7/02/2020

**EXHIBITION OF MODIFICATION REQUEST – FRASER DRIVE
RESIDENTIAL SUBDIVISION (MP 06_0243 MOD 5) – OBJECTION TO
APPLICATION**

A0001-10397160-AAR-01

## FIGURE No.DA 19

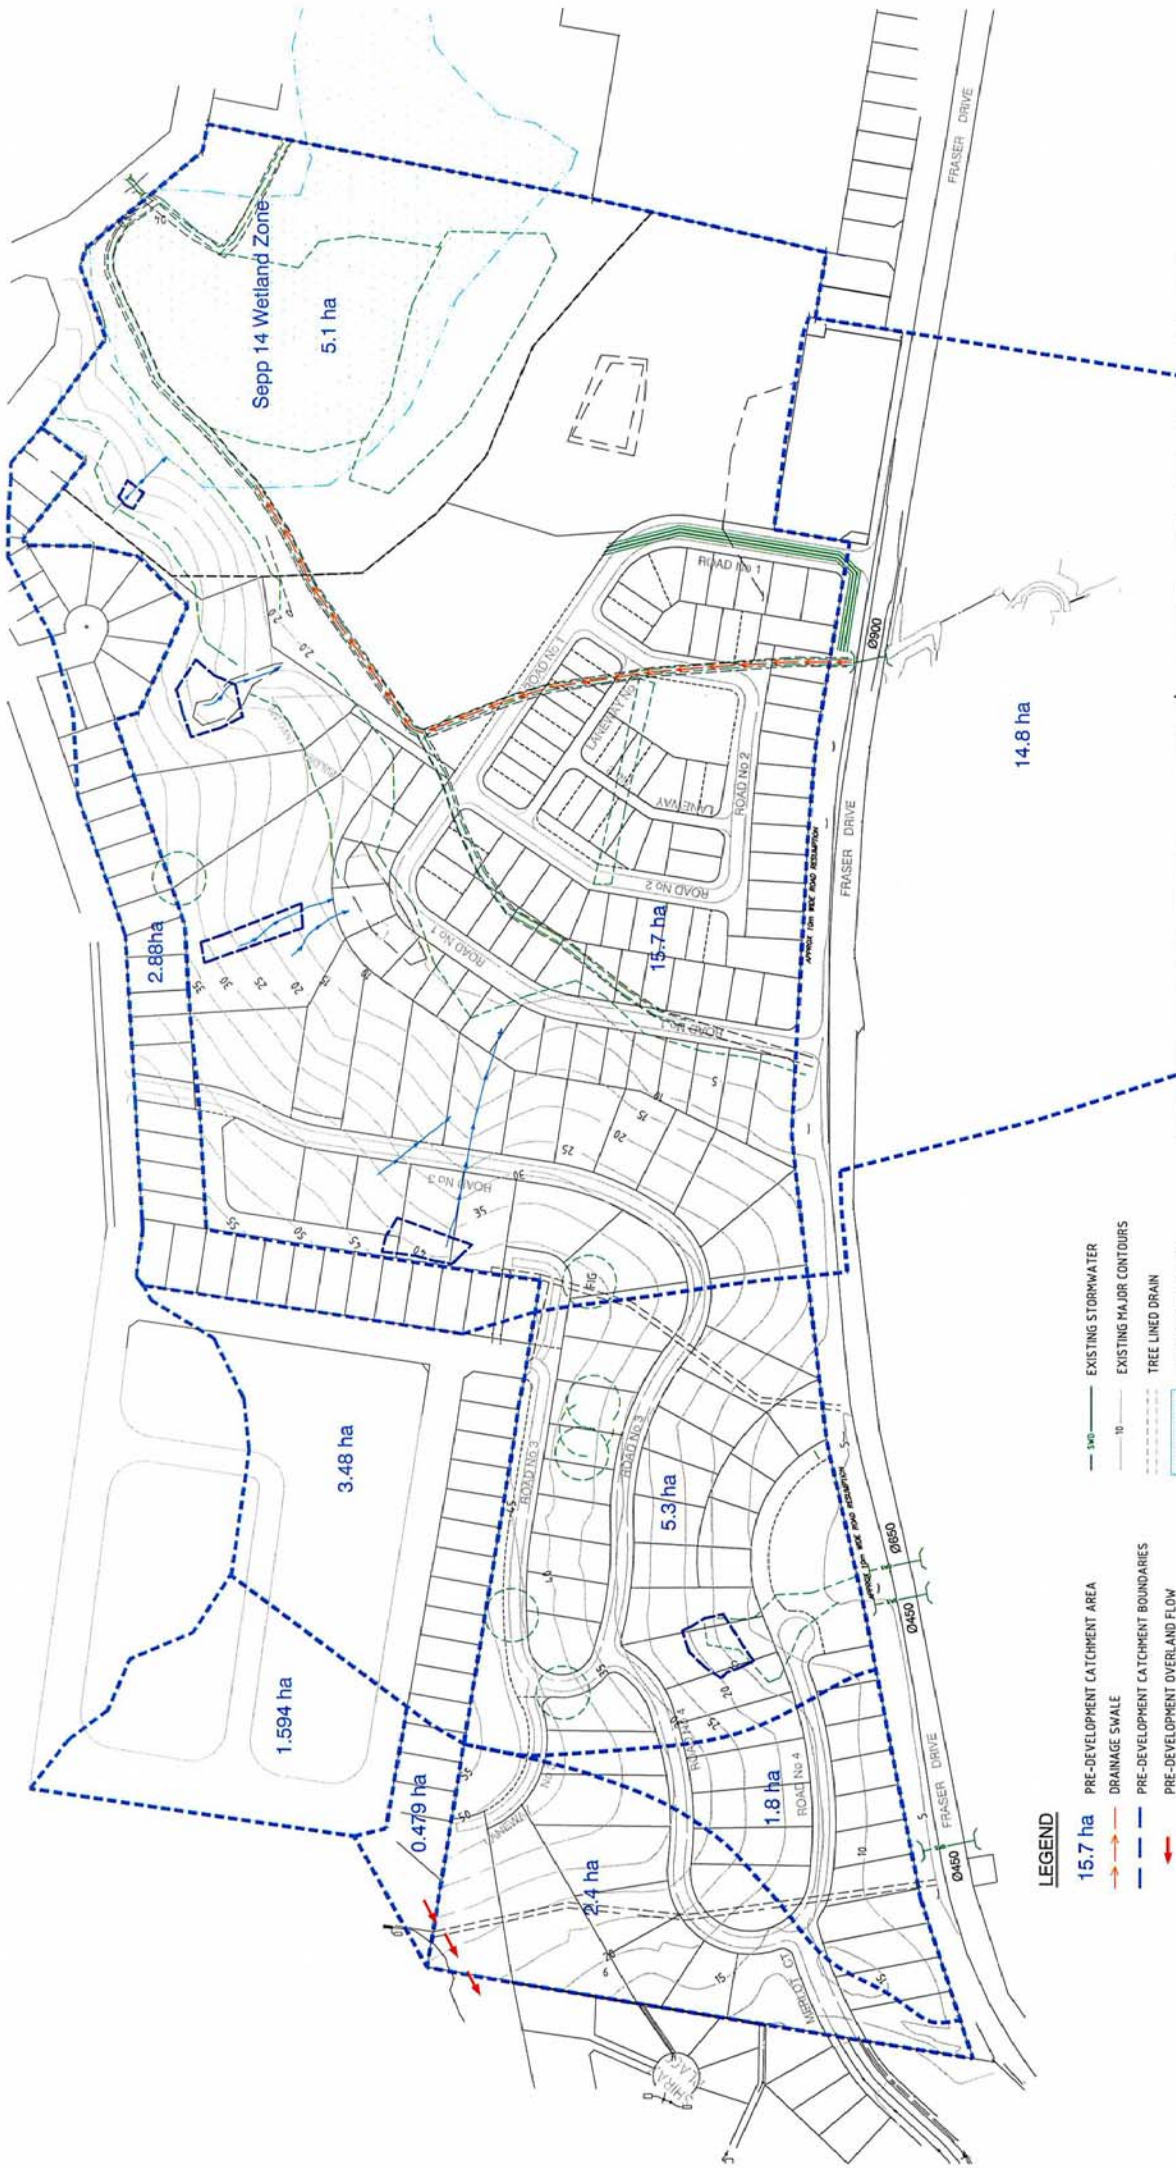
Information associated with the application shows that the proposed development will have five discharge locations described as northern, eastern, south-eastern, southern, south-western (Drawing No. 7214/29/01-DA19). Stormwater detention basins upstream of these outlets will provide a retarding volume with a desired effect to attenuate runoff leaving the development.

Two (east and south-east) of the five outlets will directly discharge stormwater to the east, across Fraser Drive into Pioneer Country and are further discussed in this letter.

This outlet is proposed to discharge stormwater across Fraser Drive to the east, into our client's property. Based on provided information the existing catchment area draining to this outlet has been increased from 8.8 ha in the existing case to 10.37 ha in the proposed (9.97 ha previously approved).

The letter states that, *'an increase in the size of the detention storage to the eastern discharge point is necessary to ensure no adverse impact due to the revised lot layout and for compliance with the original Site Based Stormwater Management Plan'*. The detention basin volume is initially sized using the Rational Method as outlined in the Cardno approved report. This calculation method is no longer supported by the latest revision of QUDM and therefore current best practice should be adopted for any resultant modifications.

The final adopted basin volume is calculated using the software XP-RAFTS in accordance with QUDM, however it is unclear how the existing and proposed imperviousness has been calculated. A table in the letter showing the catchment input parameters shows that the existing catchment (8.8 ha) has a pervious area of 5.28 ha and an impervious area of 3.52 ha which seems to correlate to the external area being 100% impervious and the site 100% pervious. Based on aerial photography, this relationship does not appear to be correct, which would lead to a higher prediction in existing flows being generated by the site.

In the developed case, for the same catchment, the relationship between pervious and impervious appears to be exactly the same as the existing case, 60% pervious to 40% impervious. It is unclear why this has not increased, to reflect current pasture site being developed with hardstand, roads and roofs. The current approach could be over estimating existing stormwater runoff rates and underestimating stormwater runoff rates

in the developed case, therefore reducing the amount of detention needed for the developed case to achieve objectives.

Notwithstanding the lack of changes in catchment imperviousness, it is unclear why 5mm has been adopted as the pervious area initial loss. QUDM Table 5.6.1 – Recommended initial loss values for use in sizing detention basins (*mm*) indicates that 5mm would only be applicable to Bare Soil (Soil Group D – Clay), which does not correlate to existing ground cover. A higher loss value would impact the calculation of existing flows leaving the site, likely to be less than currently predicted, therefore impacting on basin volume and outlet configuration.

The letter only provides 100 year ARI results and it is unclear if the basin has considered all recurrence intervals (2 year ARI to 100 year ARI) as recommended in QUDM and the UPRCT guides. From our experience, basin volume and outlet configuration arrangement can be significantly affected when all recurrence intervals are considered. It is concerning that smaller, yet more frequently occurring storm events have not been investigated and could be adversely affecting the downstream property.

Furthermore, the 100 year ARI results provided do not comply with Tweed Shire Council – Development Design Specification D5 Stormwater Drainage Design maximum discharge rate of 200L/s/ha. Results indicate a discharge rate of approximately 574L/s/ha.

Lastly the adopted basin volume provides a rate of approximately 135m³/ha which is low when compared to the UPRCT 470m³/ha. Whilst the UPRCT rate is adopted to the Upper Paramatta River Catchment and notwithstanding the fact that Tweed Shire Council – Development Design Specification D5 Stormwater Drainage Design refer to this guide, our experience indicated that a rate of approximately 350m³/ha would be expected for this area when all recurrence intervals are considered therefore reinforcing our concern that the proposed basin is undersized.

Whilst the letter states that proposed changes will not affect previously approved strategy it is unclear how pre-development flow rates will be maintained.

In addition to this uncertainty, there are unresolved issues associated with the existing cross drainage infrastructure capacity and downstream conditions at the eastern side of Fraser Drive. Any increase in flow would exacerbate the issue and we therefore seek for additional information to show this is not the case.

We recommend that modelling parameters are reviewed and a complete assessment of all recurrence intervals (2 to 100 Year ARI) undertaken to ensure current guides and planning policy are complied with.
